**J.S. THOMPSON**  
ENGINEERING, INC

July 17, 2025

Per your request, the Pappan residence under construction in Harnett county, North Carolina was reviewed to address two framing issues noted by the inspector. Analysis revealed the following:

S-1
CRAWL
FOUNDATION PLAN

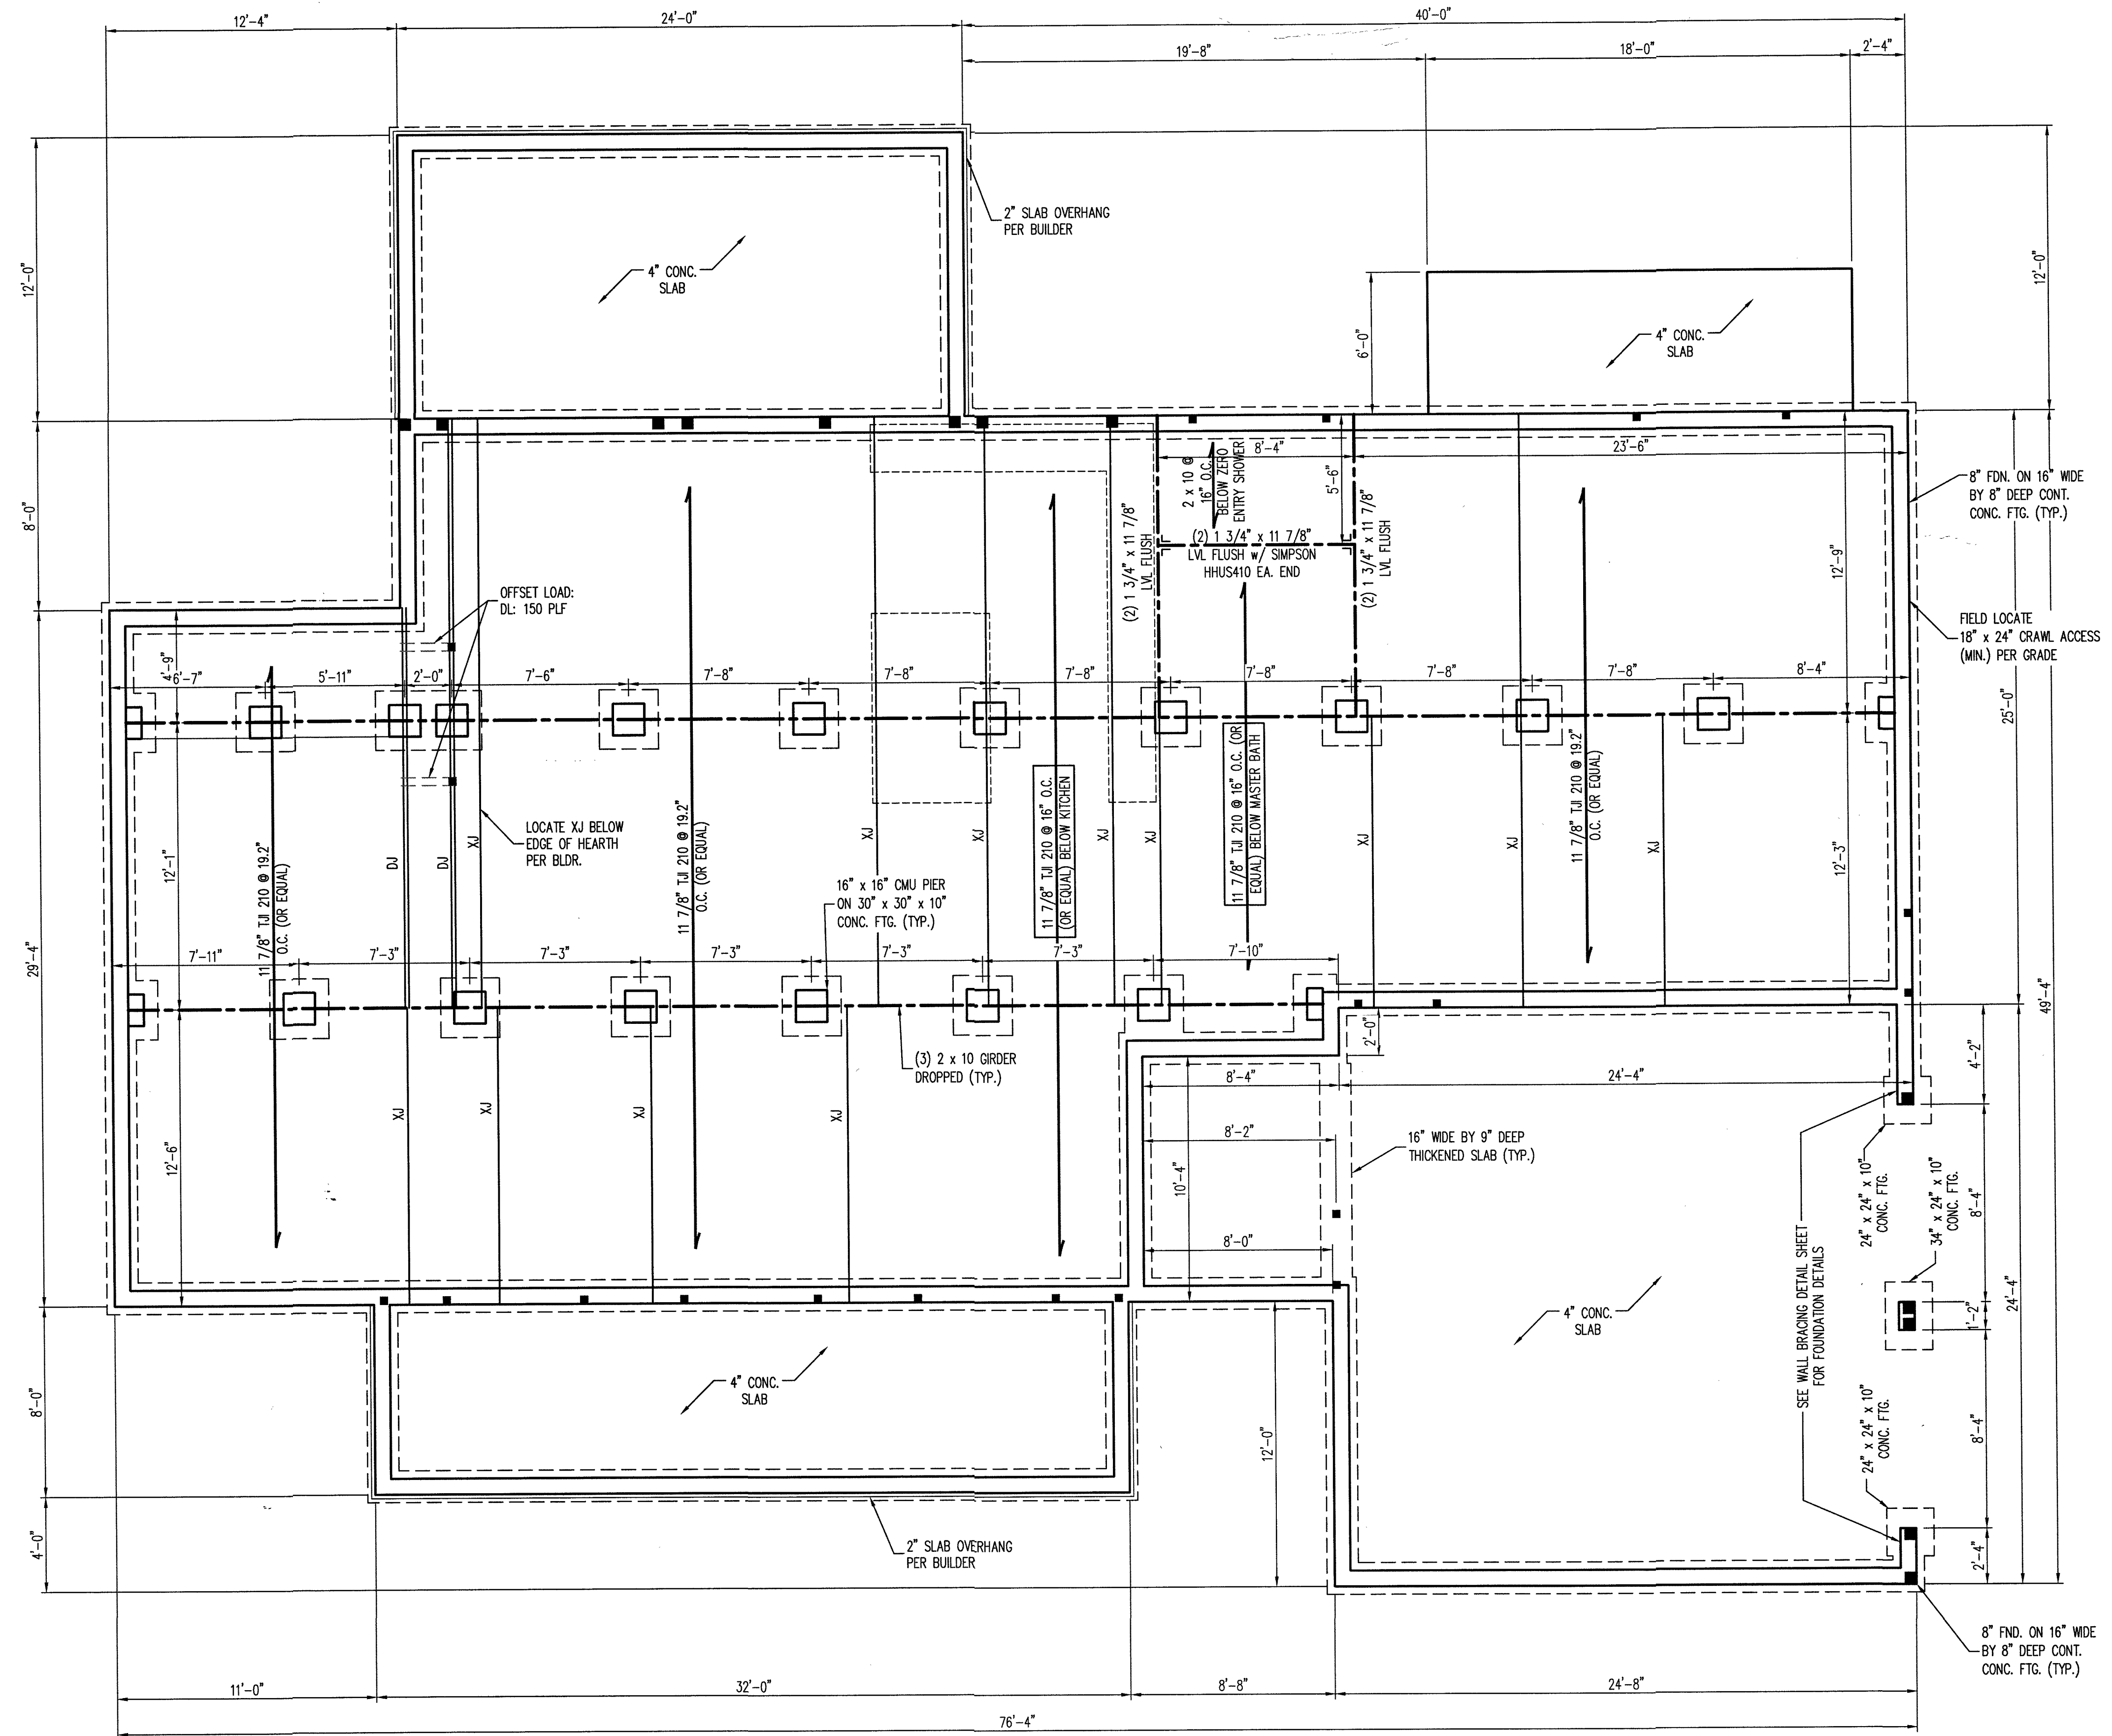
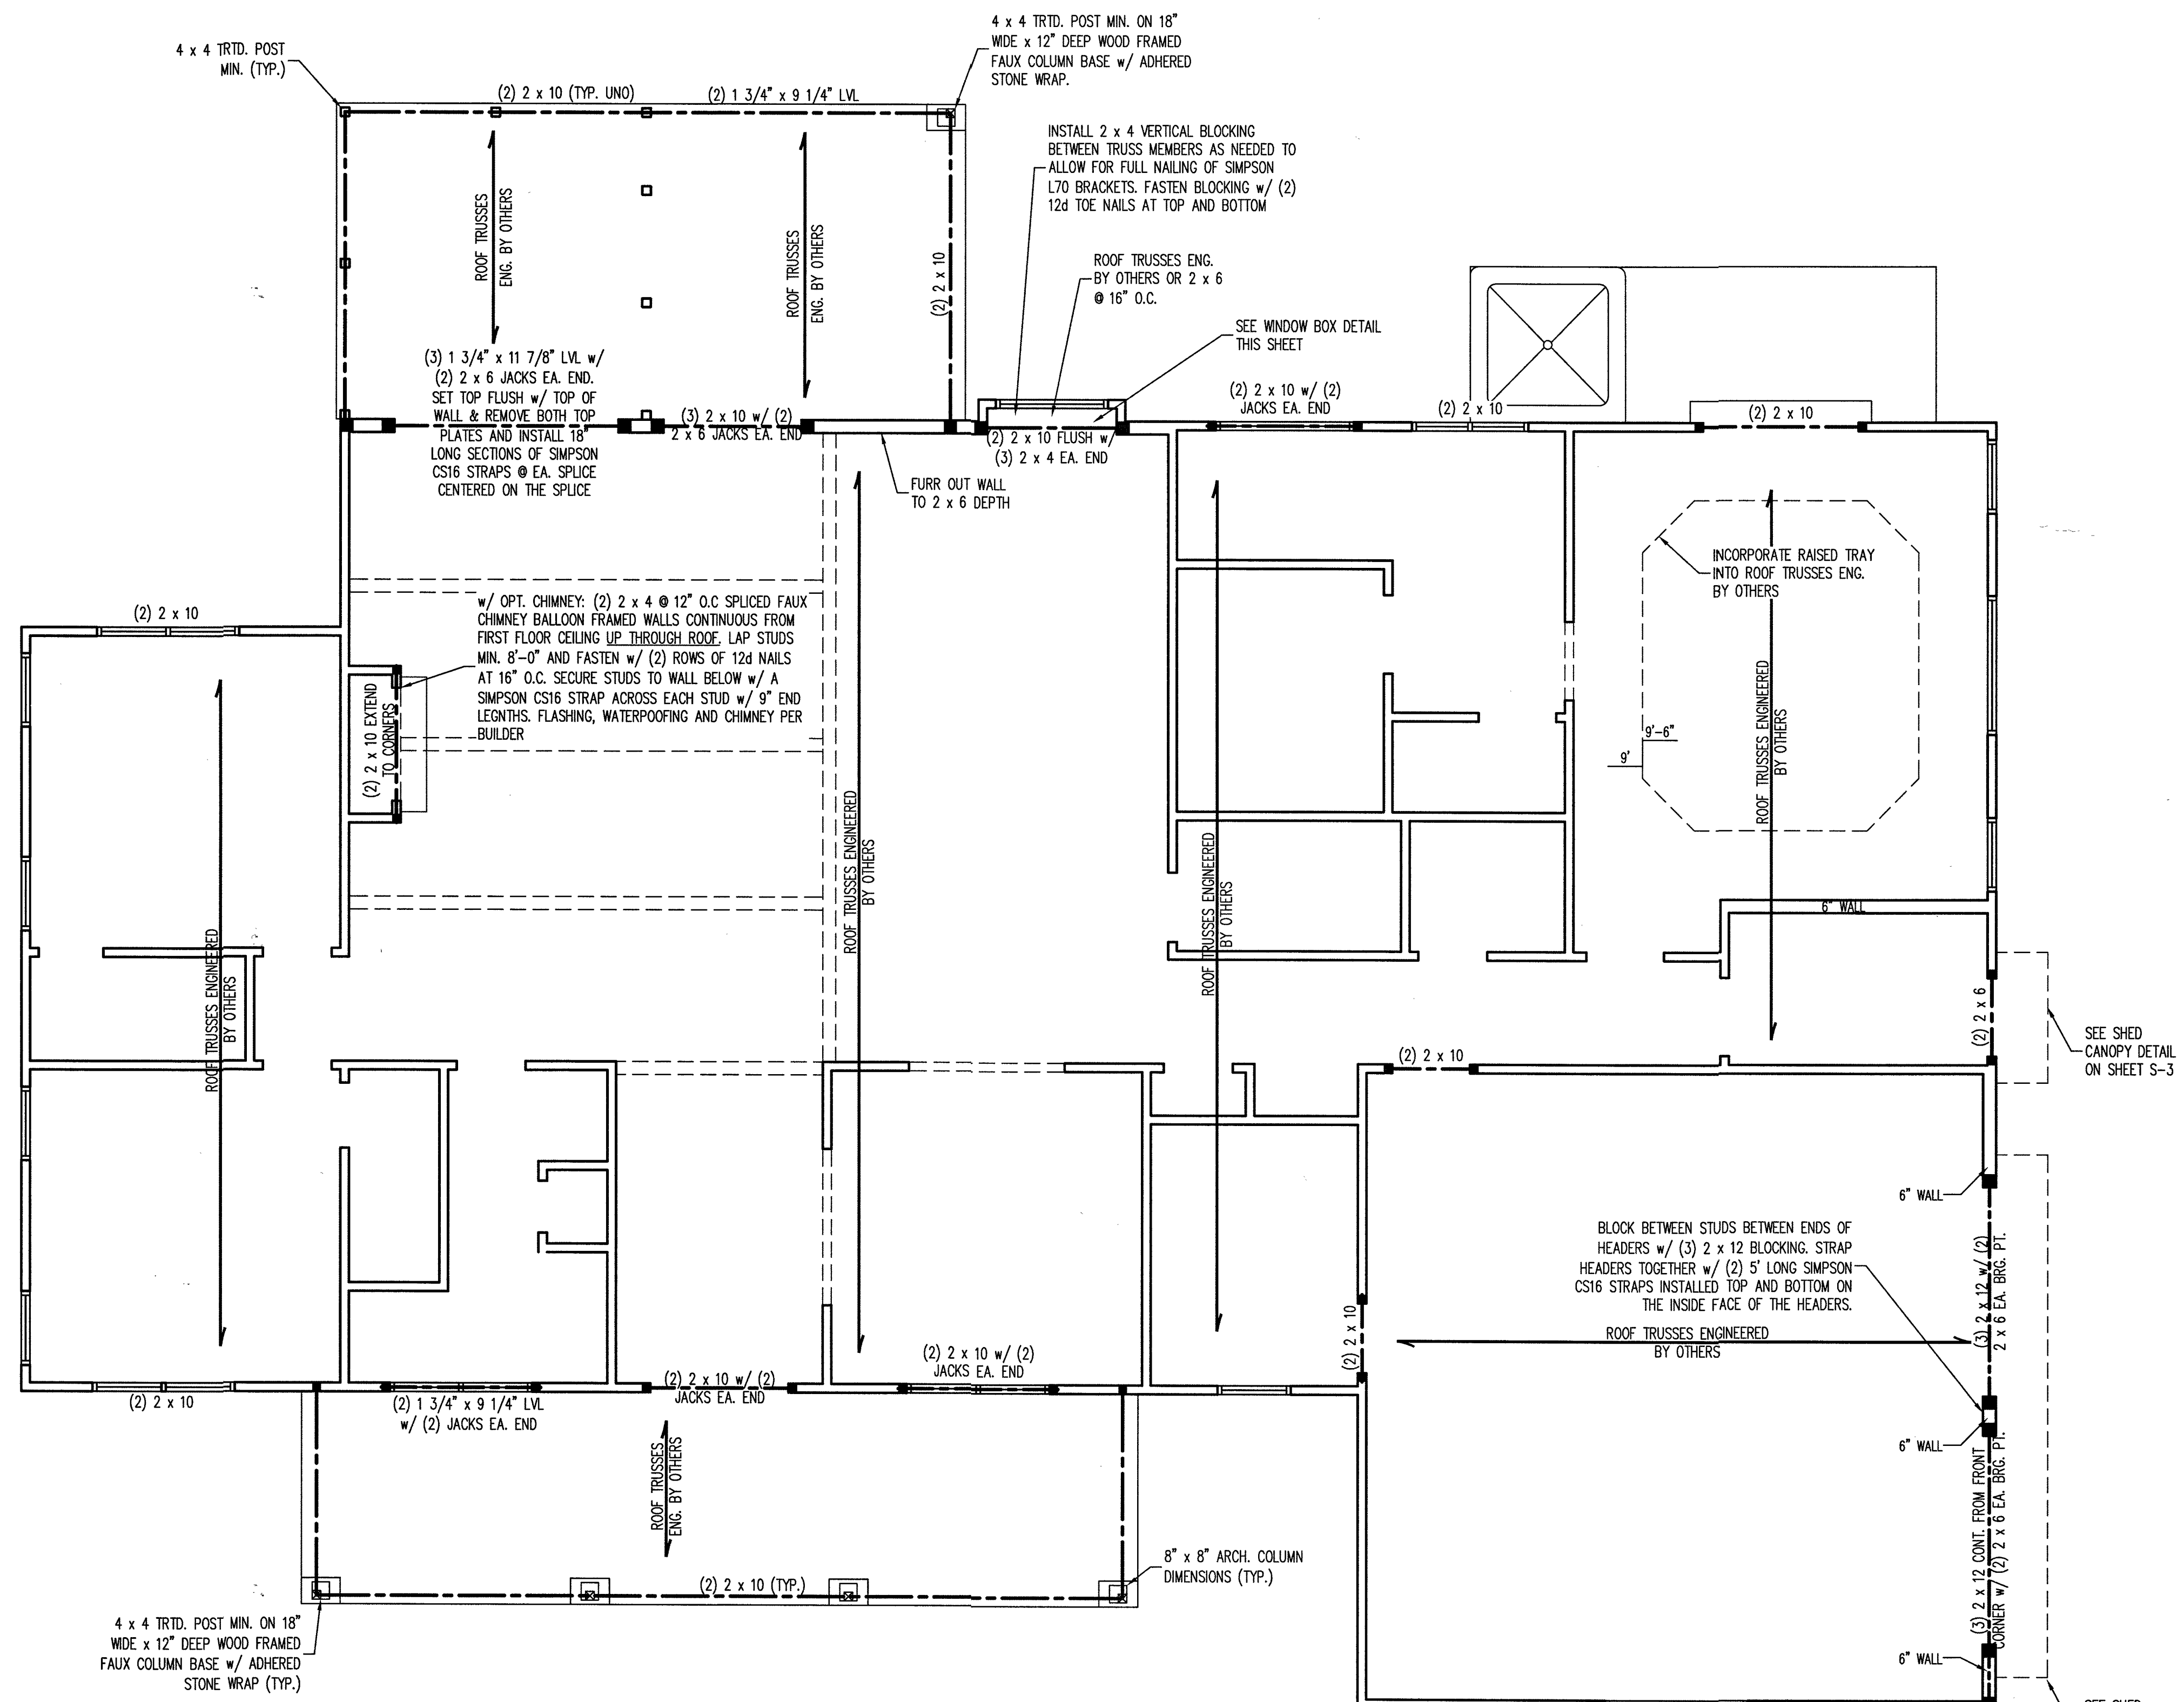
- 1) The "as-built" (2) 2 x 10 flush beam above the rear kitchen bumpout with (2) 2 x 4 at each end in lieu of the plan specified (3) 2 x 4 is suitable. No modification is required.
- 2) The sliding glass door at the rear family room wall was framed with a 8/0 x 6/8 sliding glass door in lieu of the plan specified 8/0 x 8/0 door. The "as-built" (3) 1 3/4" x 11 7/8" LVL header framed at the 6/8 header height in lieu of being set top flush with the top of the wall with both top plates removed and 18" long sections of Simpson CS16 straps centered on each splice is suitable. No modification is required.

This configuration will provide the required support for all applied loads.
